**KIRKLEES METROPOLITAN COUNCIL
DEVELOPMENT & MASTER PLANNING SERVICE**

**DELEGATED DECISION FOR PRIOR APPROVAL FOR CHANGE OF USE
FROM COMMERCIAL, BUSINESS AND SERVICE USES TO
DWELLINGHOUSES**

Reference no. 2023/CL/93447/W

Site Address	Truckline Services Ltd, Gordons Place, Manchester Road, Linthwaite, Huddersfield, HD7 5RF
---------------------	--

Drawing title: Proposed Plans & Elevations

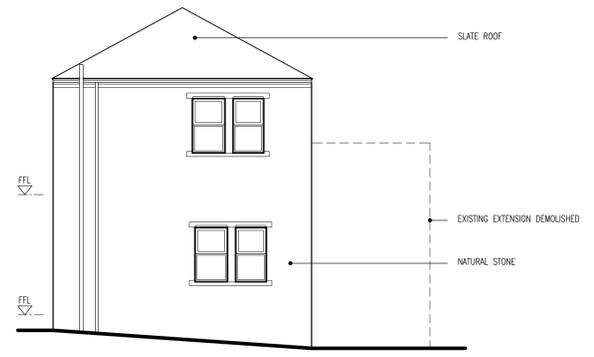
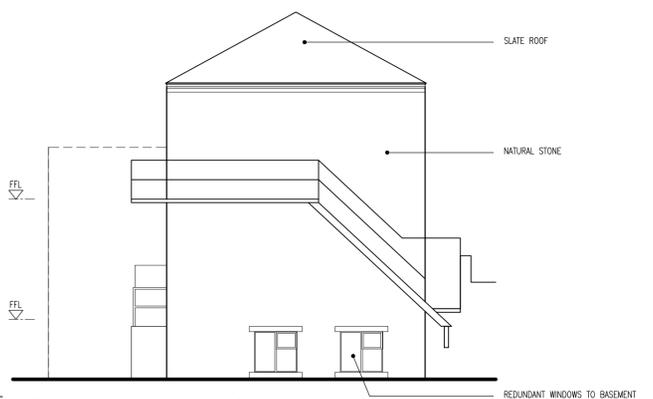
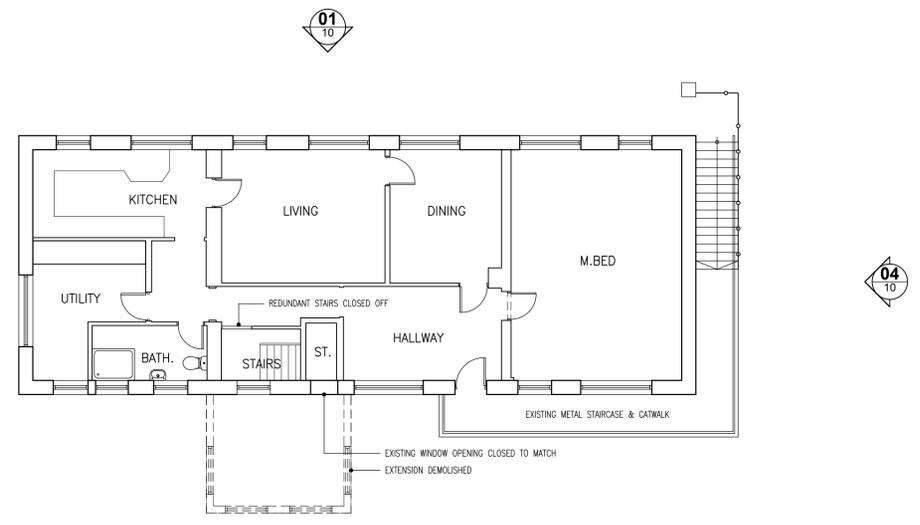
The comments have cited that there are windows demonstrated on the proposed elevations at lower ground floor level which have not been demonstrated on the proposed floor plans. Subject to the lower ground floor not being used for habitable space, there are no objections to the application in terms of flood risk. This can be secured by condition, should the application be granted consent.
